**Consultation Response from KC,
Highways Development Management**

2024/90171 10, Peat Ponds, Salendine Nook, Huddersfield, HD3 3UA

Erection of replacement dwelling

Date Responded: 06/06/2024.

**GROUND FLOOR**  
 1 : 50

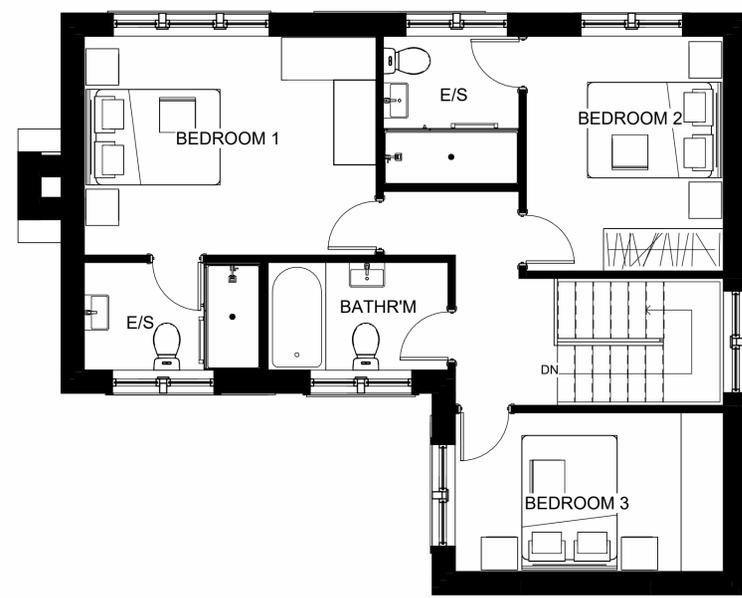
The site layout does not satisfactorily demonstrate that sufficient parking, turning and manoeuvring space would be available to serve the proposed dwelling.

However, the parking spaces do not work as shown on the plan. The end parking space is tight, and a vehicle would not be able to access this space, especially if a vehicle was parked in the adjacent bay.

A revised drawing showing a swept path analysis to show that vehicles can access the spaces and turn to leave the site in forward gear needs to be provided.

No bin storage areas are shown. A bin collection/presentation point should be located adjacent to the public highway. The bin collection/presentation point must not obstruct the adopted highway or the access road.

Details of waste storage and collection should be provided, with the location of a waste collection presentation point being clearly marked on a drawing in such a location that is easily accessible to the collection team and where it will not obstruct the parking, access or the adopted highway for road safety reasons.
